WELWYN HATFIELD COUNCIL – DEVELOPMENT CONTROL
DELEGATED REPORT

APPLICATION No:	S6/2009/2749/FP
------------------------	------------------------

The application seeks full planning permission for the 'erection of a two storey residential extension, first floor granny annexe and B1 (office) replacement following demolition of existing ground floor offices.'

PROPOSED PLANS AND ELEVATIONS

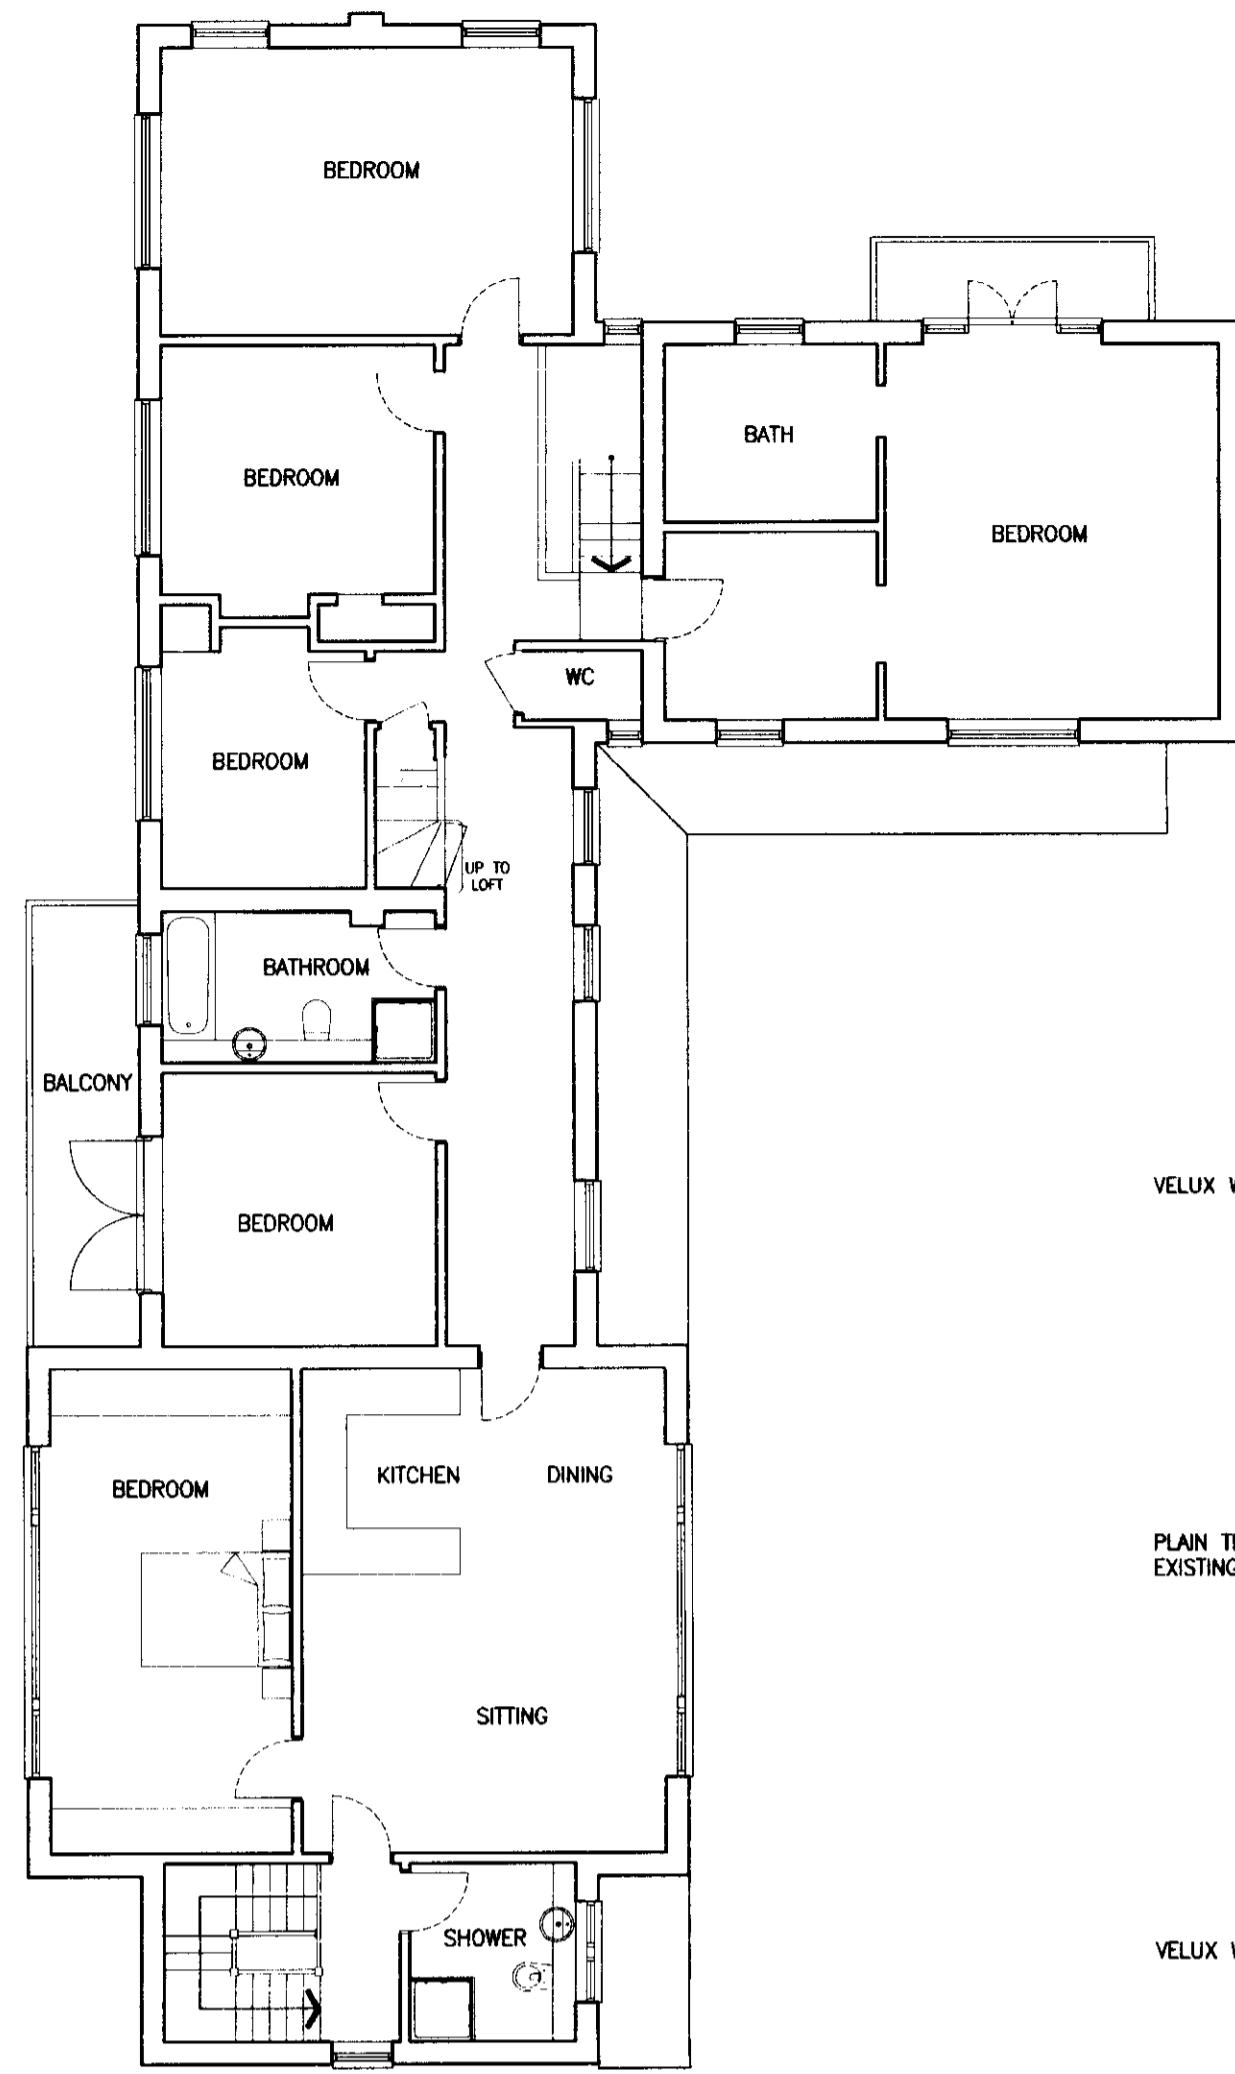
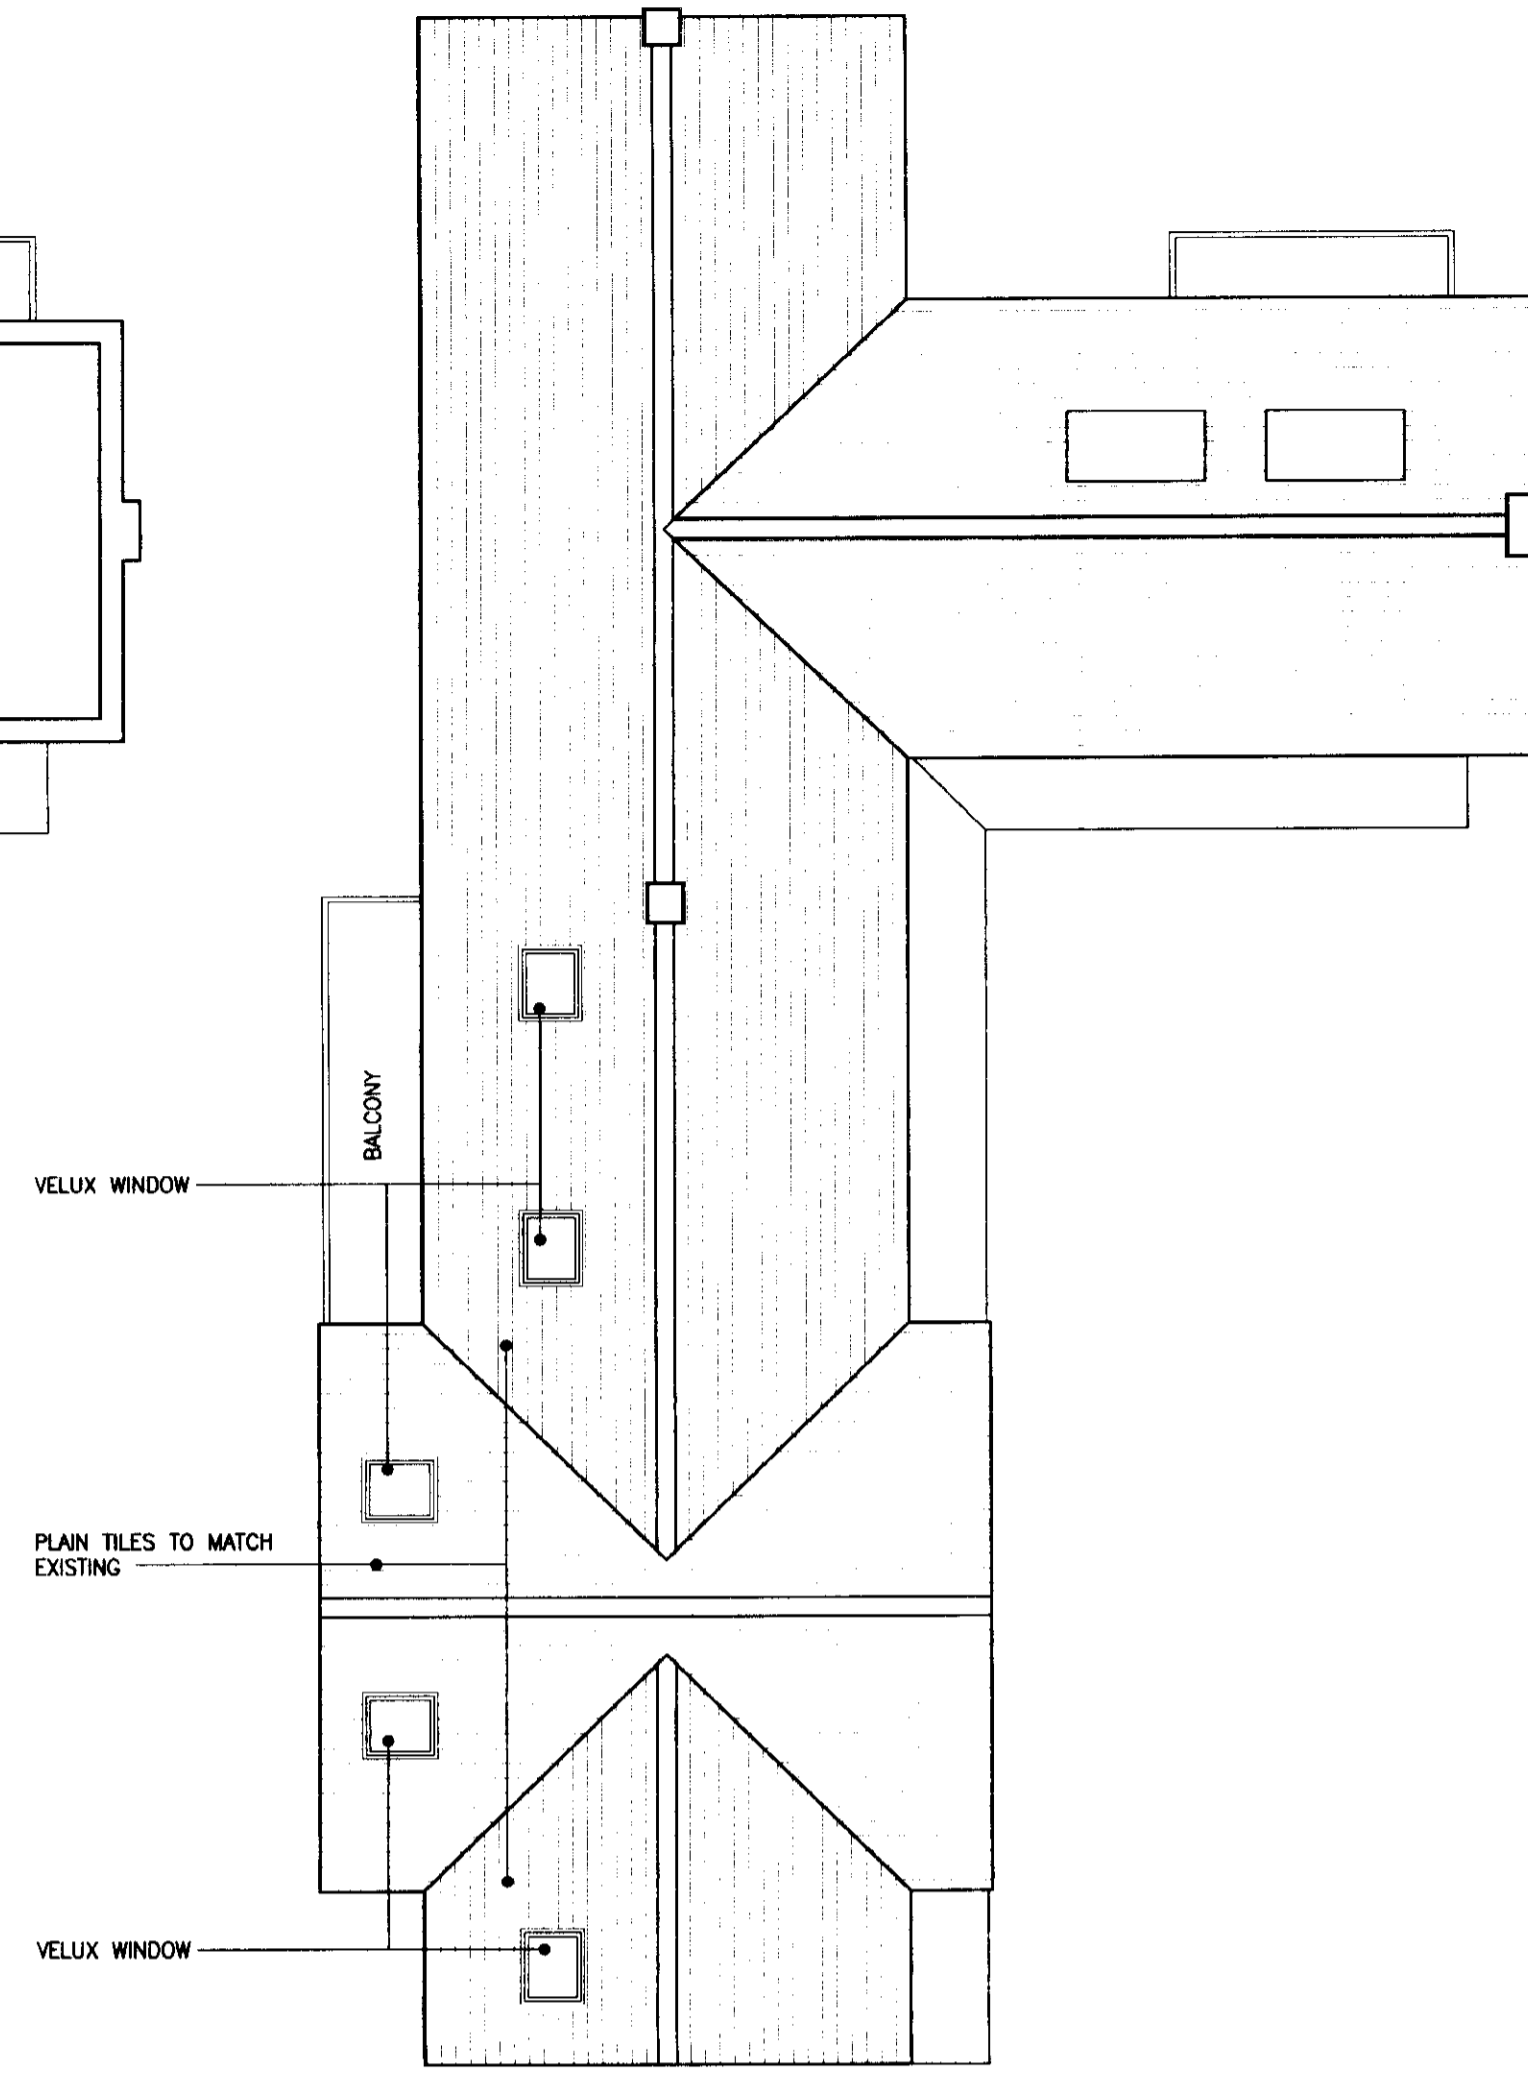
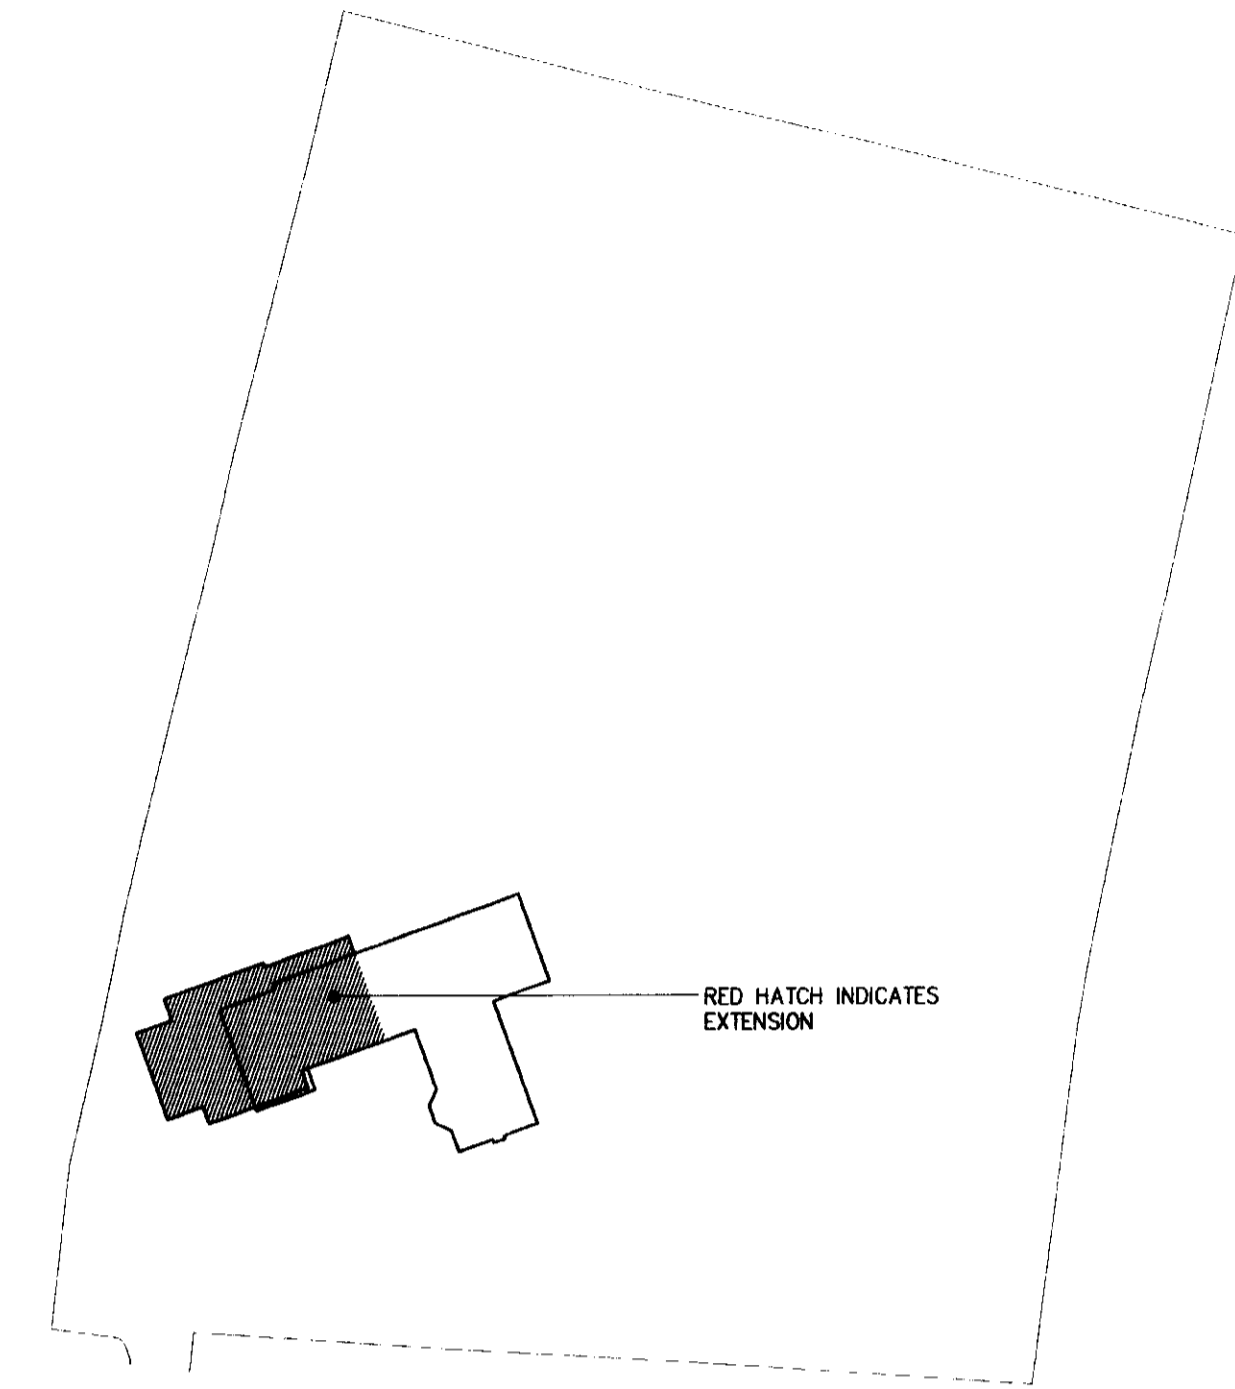
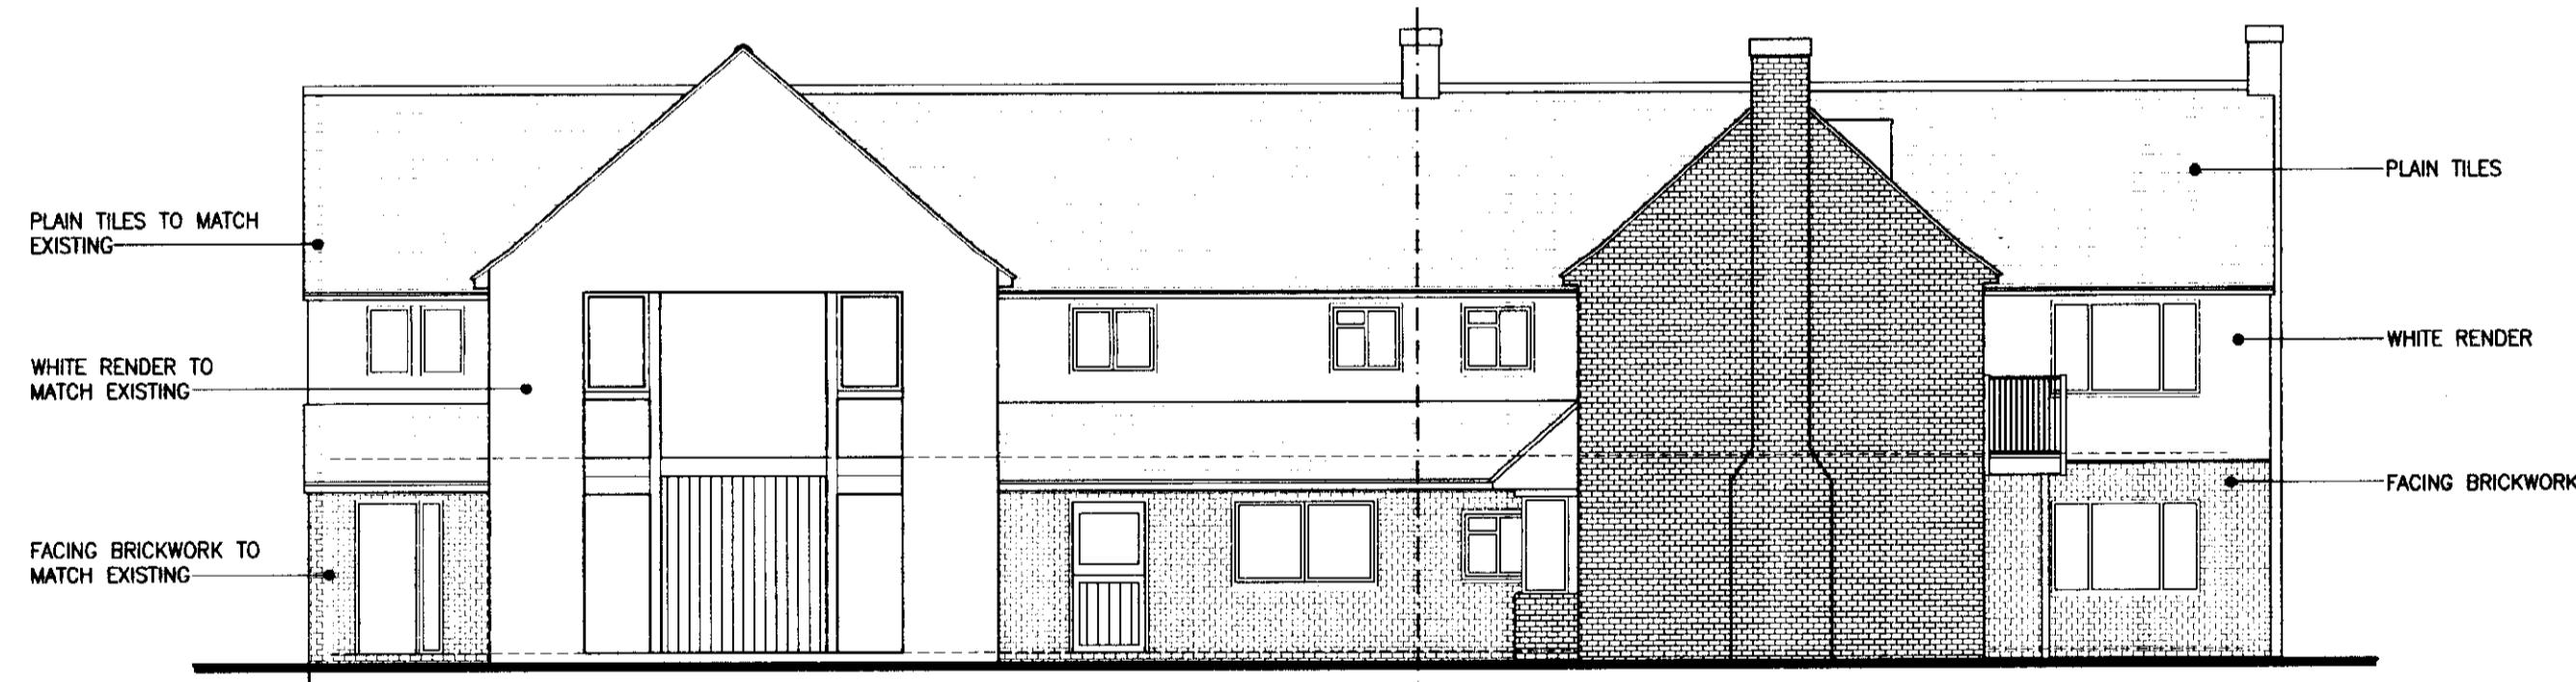
The proposed new resultant floor areas comprises approximately 174 sqm at ground level and approximately 228 sqm at first floor level giving an overall resultant floor area of approximately 402 sqm. This would result in an overall increase in new habitable residential floor areas since the 'original dwelling was built of 250 sqm which is approximately 164 % increase of floor area compared to the 'original' dwelling.

In regards to an assessment of height and overall mass, the proposed extensions would not increase the height of the 'original' dwelling, but would add significantly further to its overall mass. Although the east side of the dwelling would remain in its existing form, the resultant building would increase significantly to the west with the proposed two storey extensions. This increase in mass along with the increase in

habitable floor areas of 164% would result in a disproportionate addition over and above the size of the 'original' dwelling. The proposal is therefore considered to represent inappropriate development in the Green Belt. The proposal would fail the requirements of Criteria (i) of Policy RA3 and also PPG2.

- 1. The cumulative effect of the proposed development would, when considered in relation to previous extensions to the dwellinghouse, result in disproportionate additions over and above the size of the original dwelling due to the increase in the resultant floor area, size, bulk and mass. This would significantly reduce the openness of this part of the Green Belt to the harm of the rural character of the area contrary to the requirements of Policy RA3 of the Welwyn Hatfield District Plan 2005 and Planning Policy Guidance Note 2 (Green Belt). There are no very special circumstances which have been advanced to justify a departure from the Green Belt Policies of restraint.
